Application for a non-material amendment following a grant of planning permission.

Number	1
Suffix	
Property name	
Address line 1	Finch Gardens
Address line 2	
Address line 3	
Town/city	Bersted
Postcode	PO22 9EQ
Description of site location must be completed if postcode is not known:	
Easting (x)	492987
Northing (y)	101096
Description

Erection of 1no. attached dwelling	
Reference number:	BE/74/18/PL
Date of decision	10/07/2019

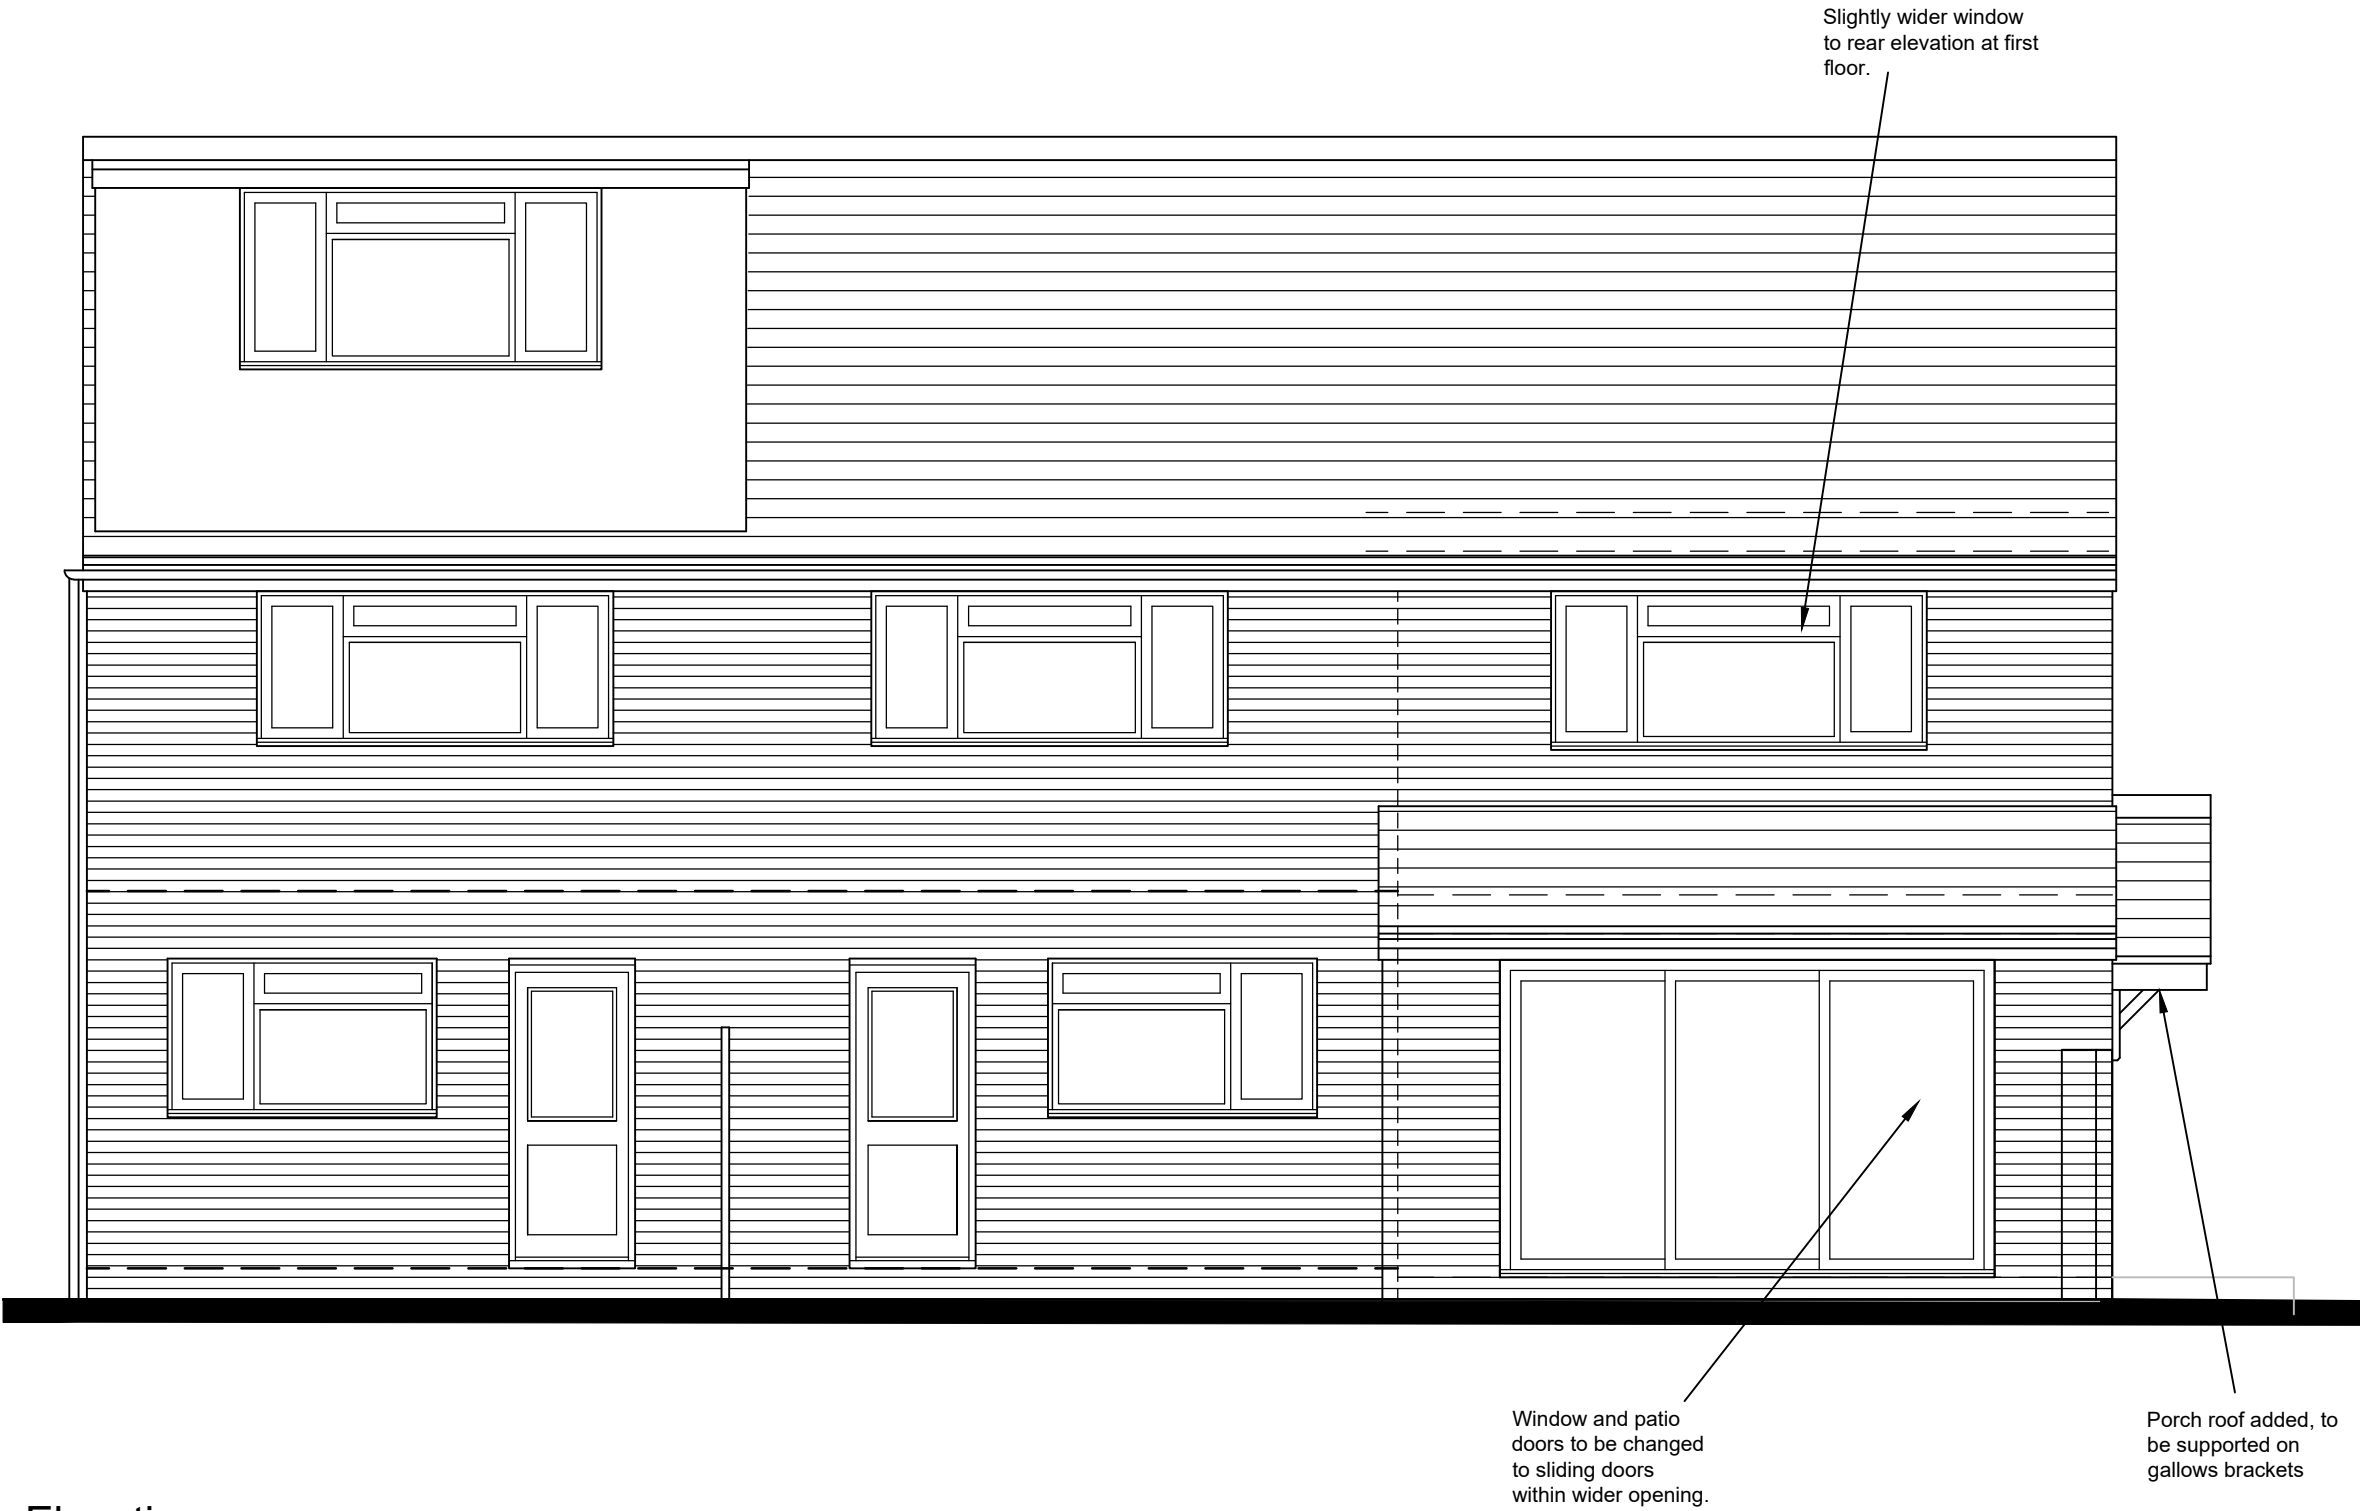
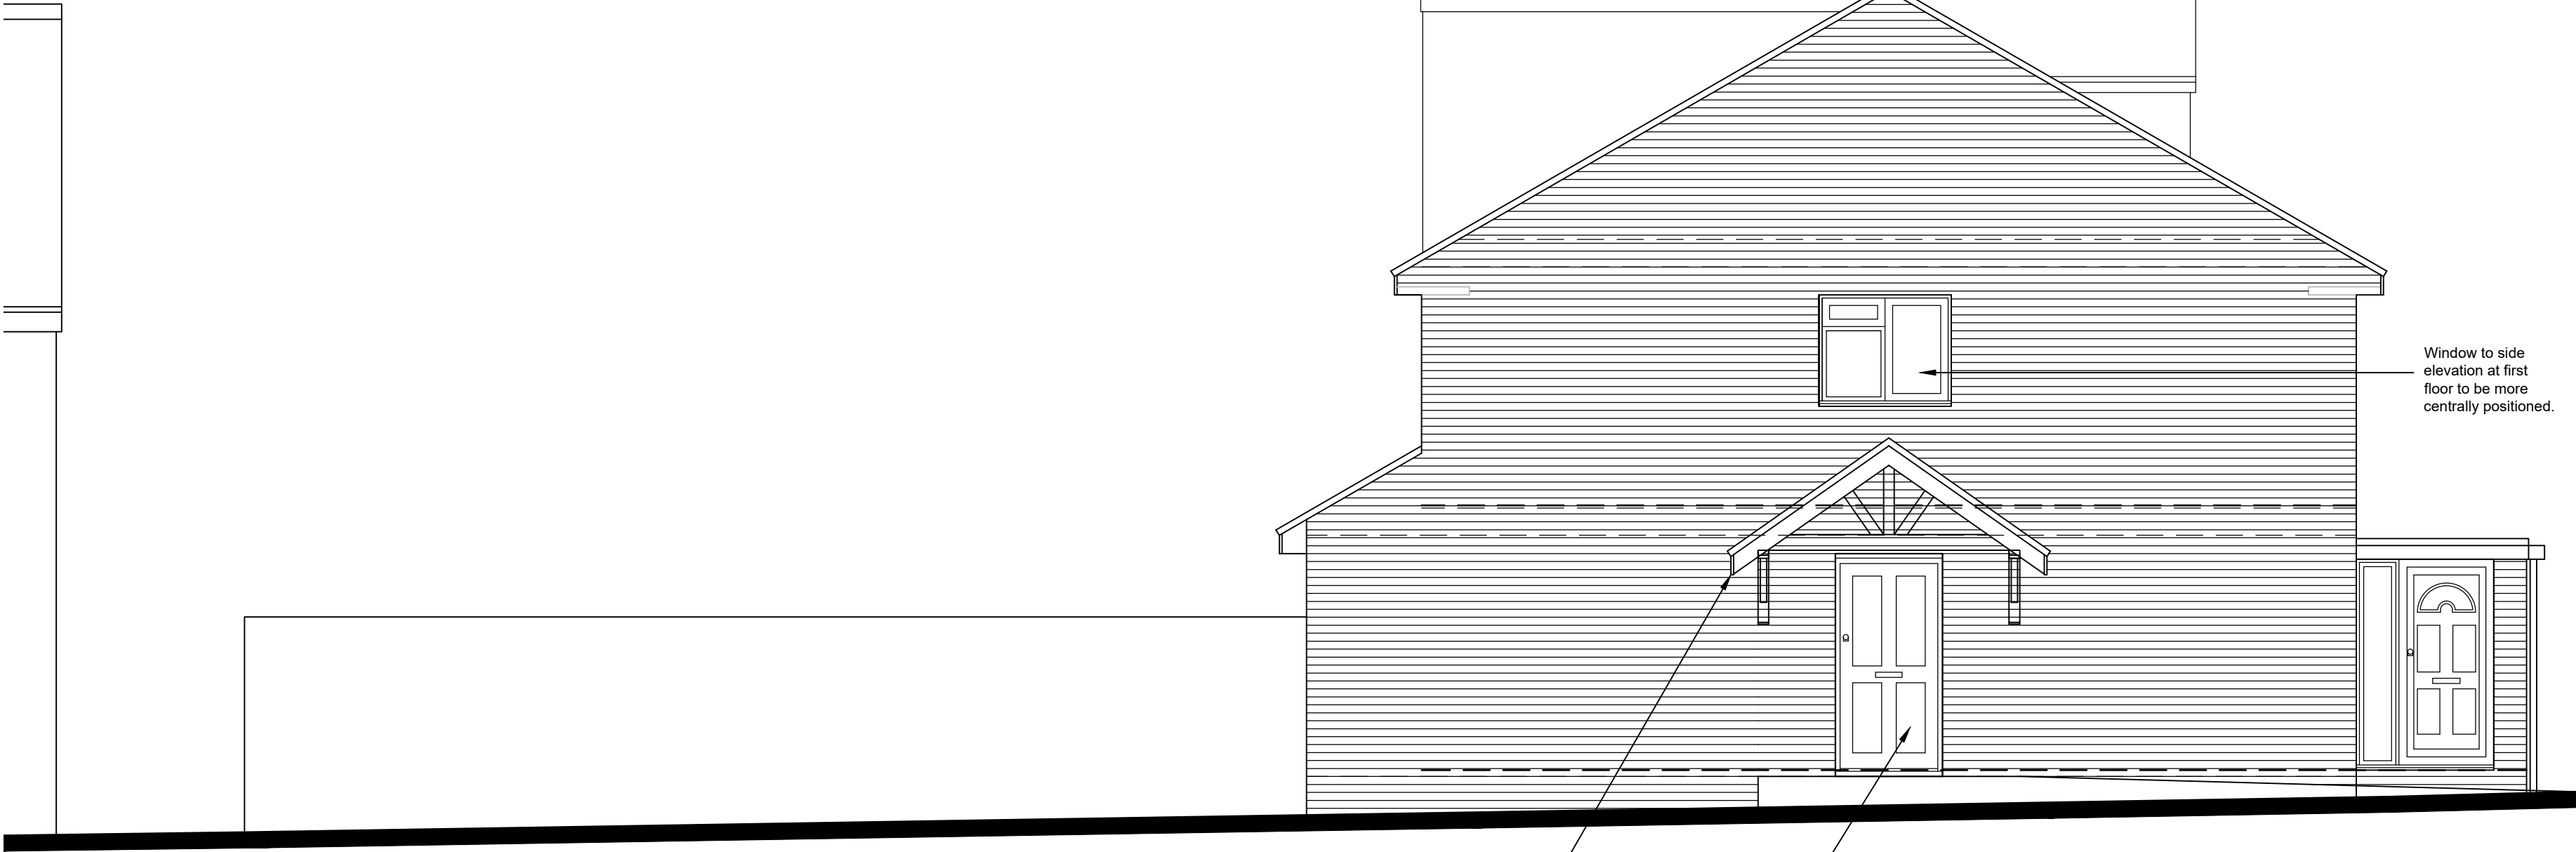
Front door moved to side of house and new porch roof canopy supported on gallows brackets and new path provided.
Windows on front elevation decreased slightly in width and centred.
First floor window on side elevation centred.
First floor window on rear elevation to be made slightly wider.
Ground floor door and window on rear elevation to be replaced with sliding doors within a wider opening.
Short side wall to rear projection to be moved away from existing house by approx. 20mm, so that its foundation can be 500mm clear of public sewer manhole.
The ground floor rear wall has been moved out by 25mm, so that the long side wall of the house works to brick dimensions.
Internal layout altered.
